Re: Formal Objection to SSD-82900461 – Concept Proposal for a Residential Flat Building with In-fill Affordable Housing at 11-19 Middle Harbour Road, Lindfield

I write to formally Object to **SSD-82900461** Concept Proposal for proposed residential flat building with in-fill at **11-19 Middle Harbour Road, Lindfield**, on multiple grounds related to non-compliance with statutory thresholds, planning controls, heritage conservation, environmental impacts, and community consultation deficiencies.

A

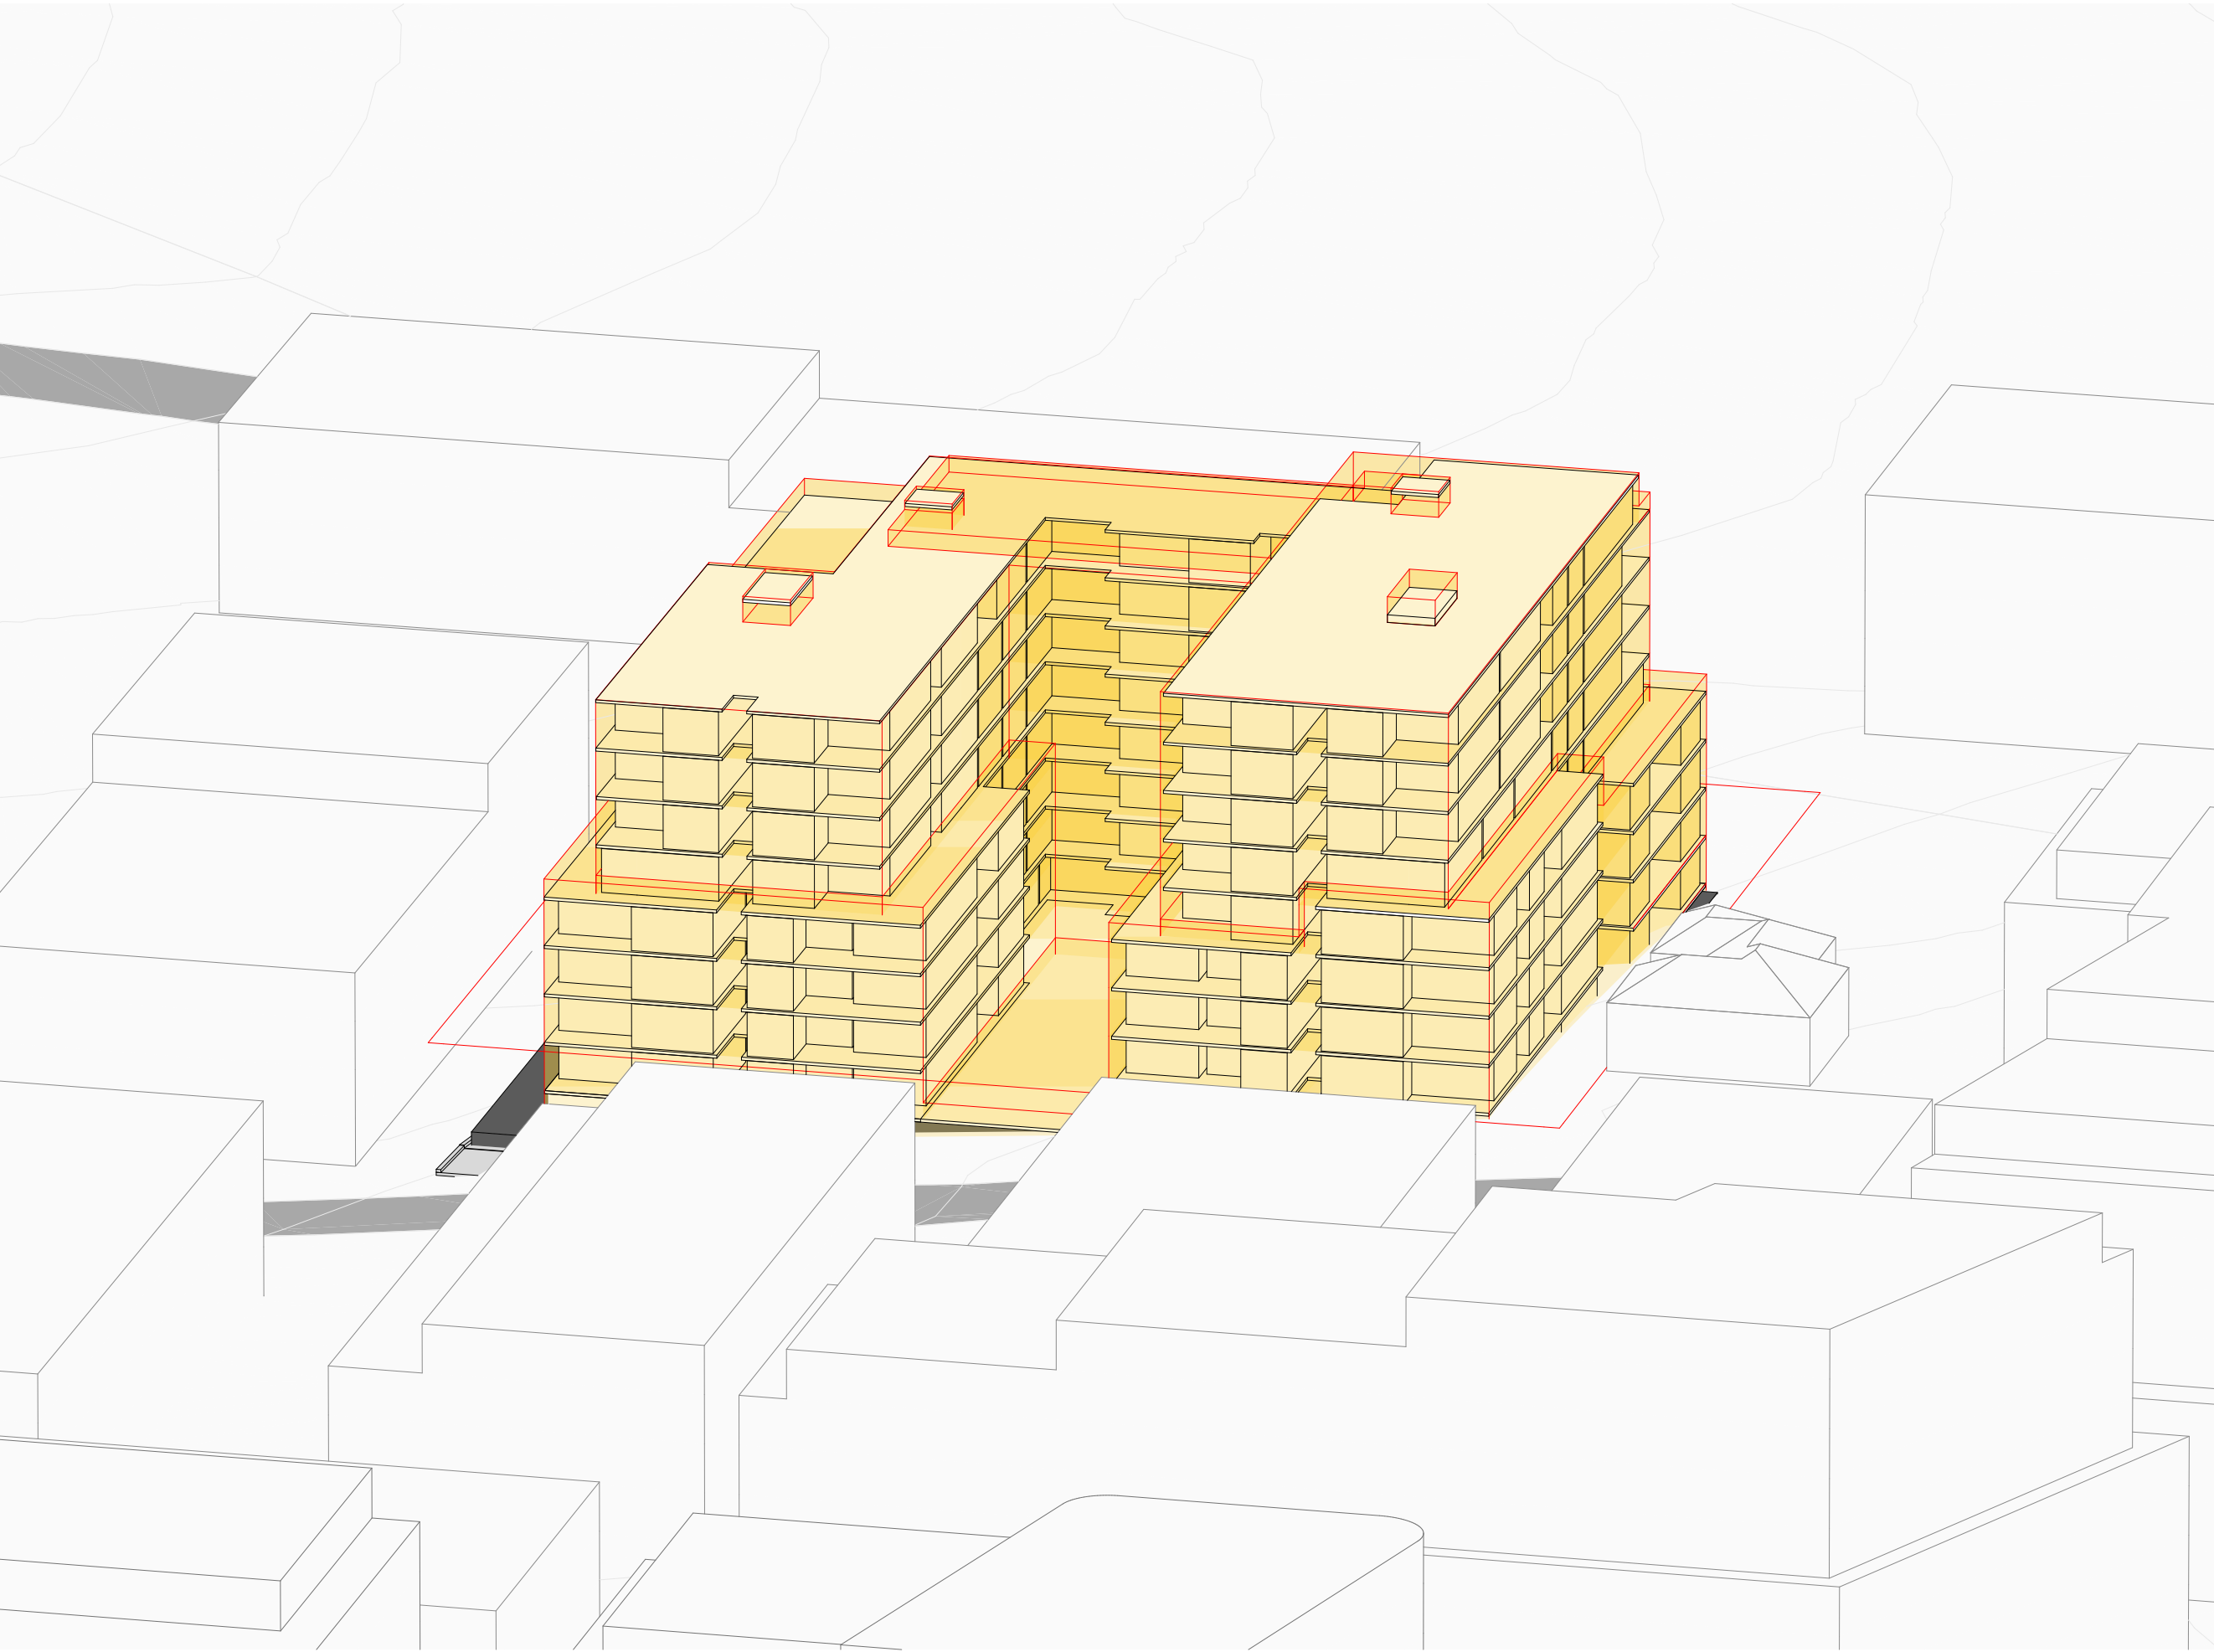
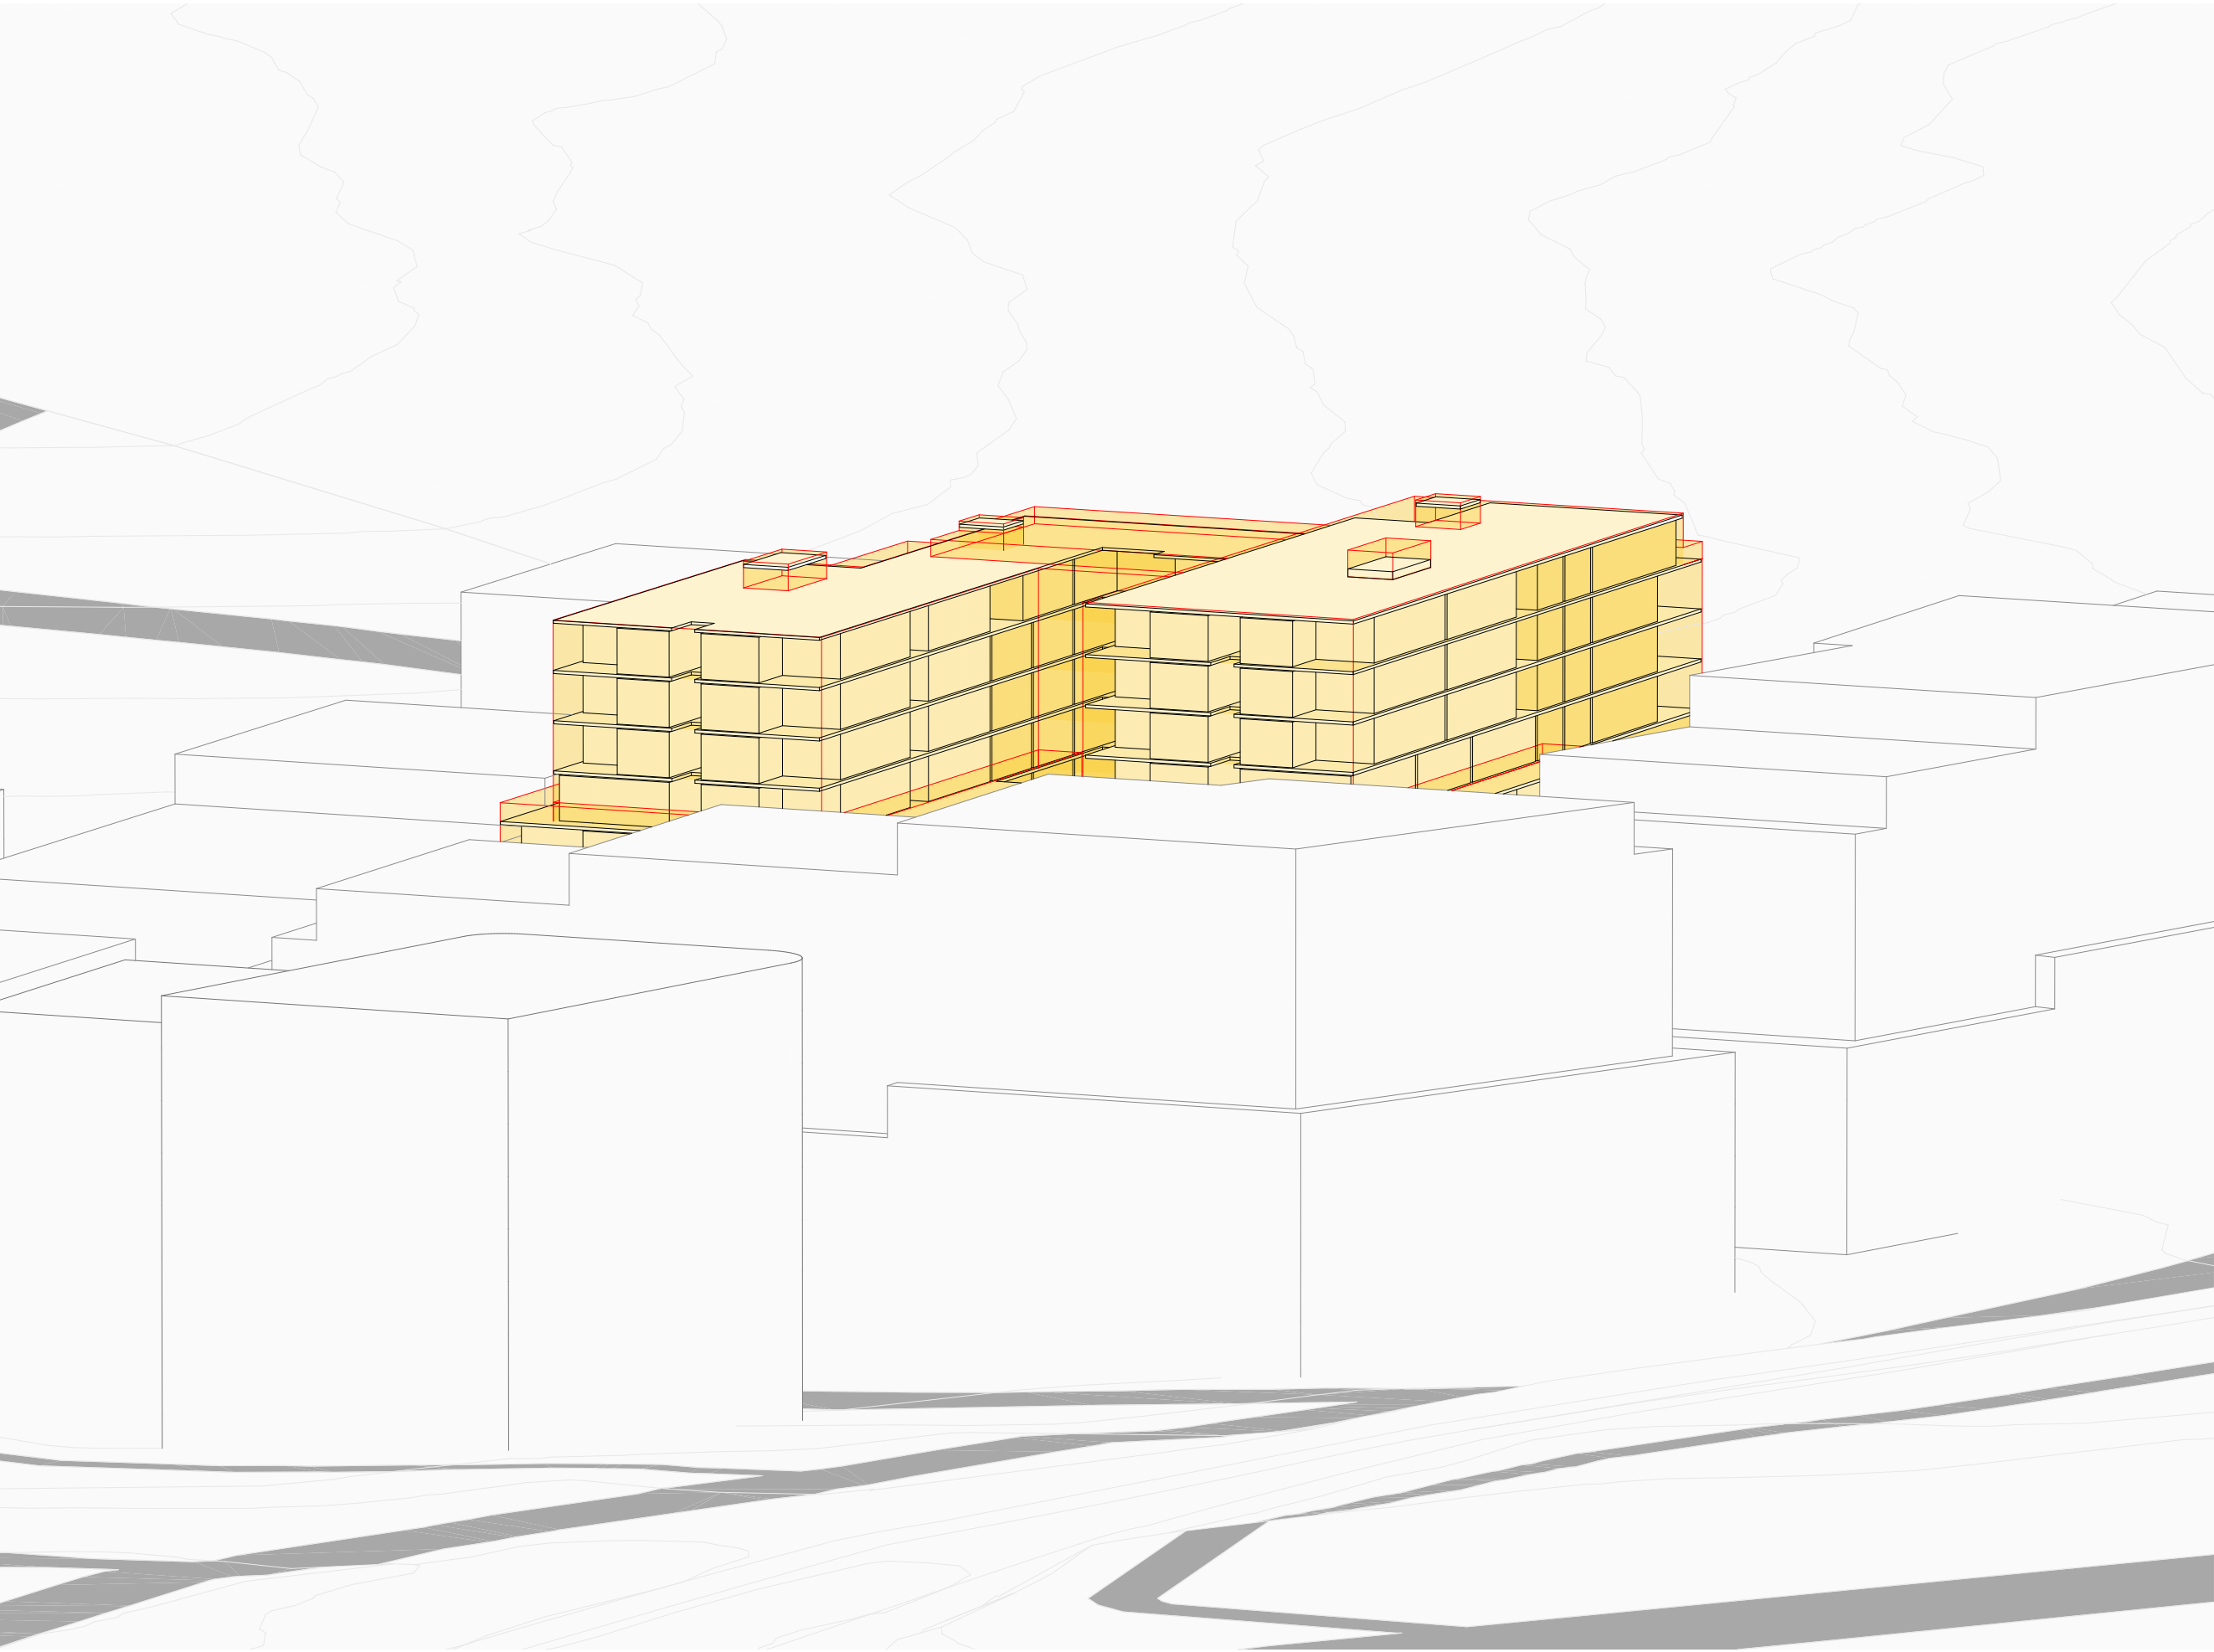
The application omits detailed, compliant sunlight and shadow diagrams as required by the Ku-ring-gai DCP and relevant SEPPs. This prevents transparent and proper assessment of overshadowing impacts on neighbouring properties.
